Re: Wongawilli Coal (PA 09_0161 MOD2) modification report

I refer to your request of 4 February 2021 for advice regarding Wongawilli Colliery's modification report (MOD2) for North West Mains Development. The Resources Regulator has reviewed the request.

Figure 2: Plan of proposed MOD2 Layout with identified surface features and previous mine workings.

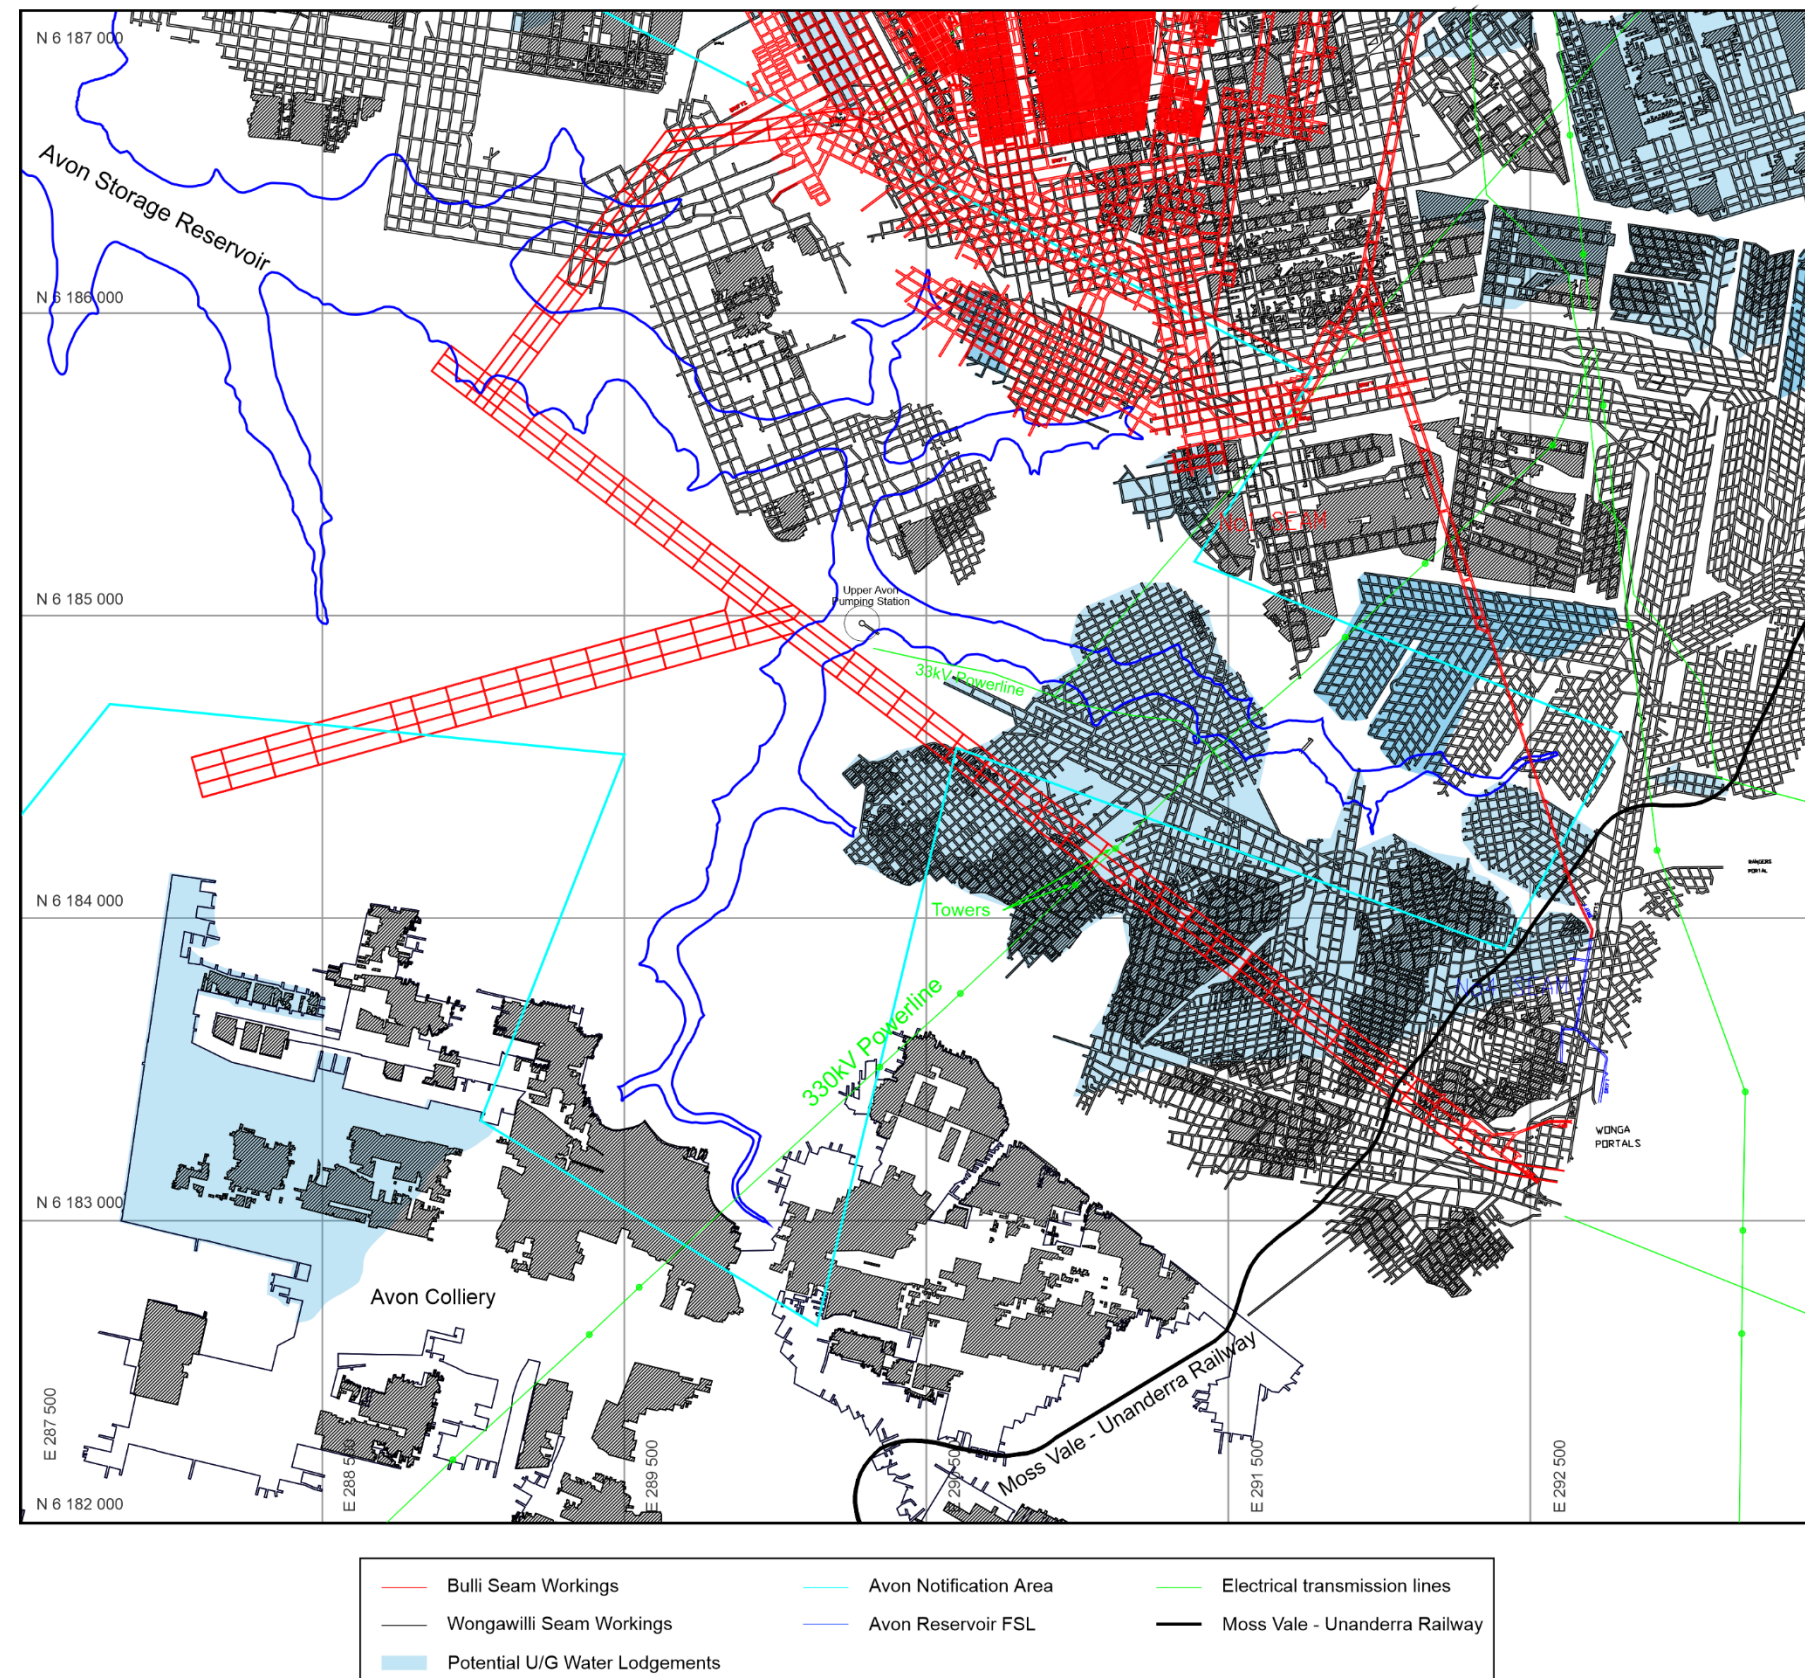
The presence of important natural and built surface features above the proposed NWMD including the Illawarra Escarpment, the Moss Vale to Unanderra Railway Line and Transgrid's Avon to Marulan 330kV power transmission line is critically important.

Development and implementation of effective subsidence monitoring programs and risk management plans for these surface features must be a requirement of the Conditions of Development Consent. Monitoring and management must include consideration of the

shallow depths of cover between the proposed workings and parts of these surface features.

Figure 5: Plan of Proposed MOD2 Layout relative to geological structure and existing mine workings.

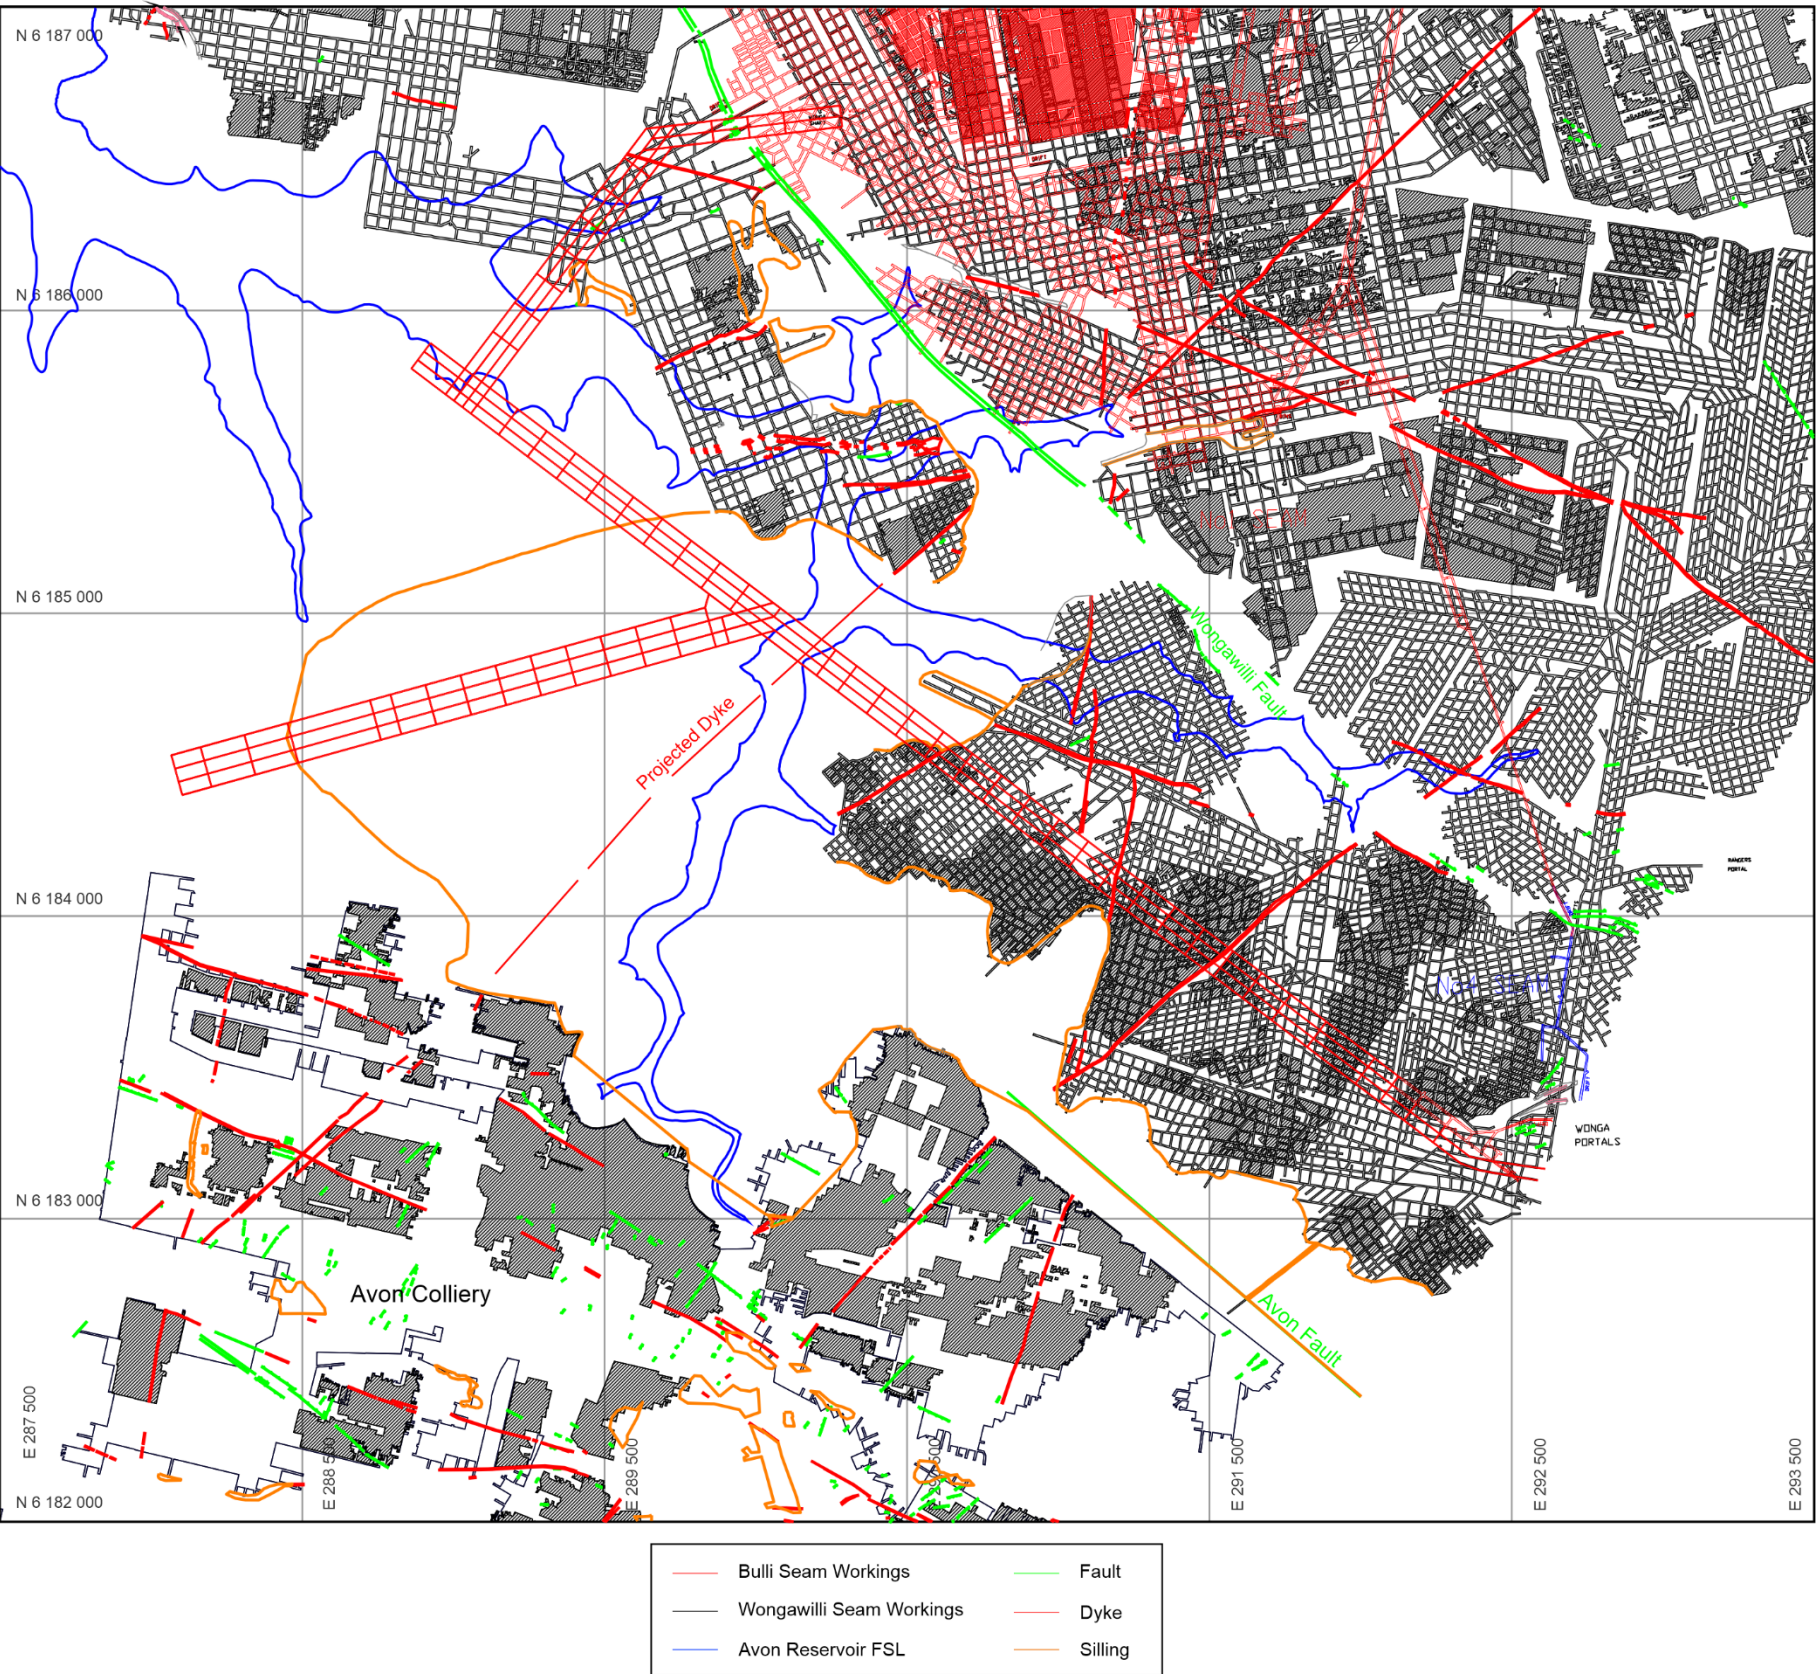
The Regulator notes that the first workings in the North West Mains Development (NWMD) are within approximately 60 metres of the base of the Avon Reservoir and intersect a dyke. The mine should undertake a review of the Inrush and Inundation Risk Assessment and the Inrush and Inundation Principal Hazard Management Plan prior to undertaking the planned activities.

In addition, potential interactions between the proposed NWMD and the underlying old mine workings must also be considered and any risks managed appropriately.
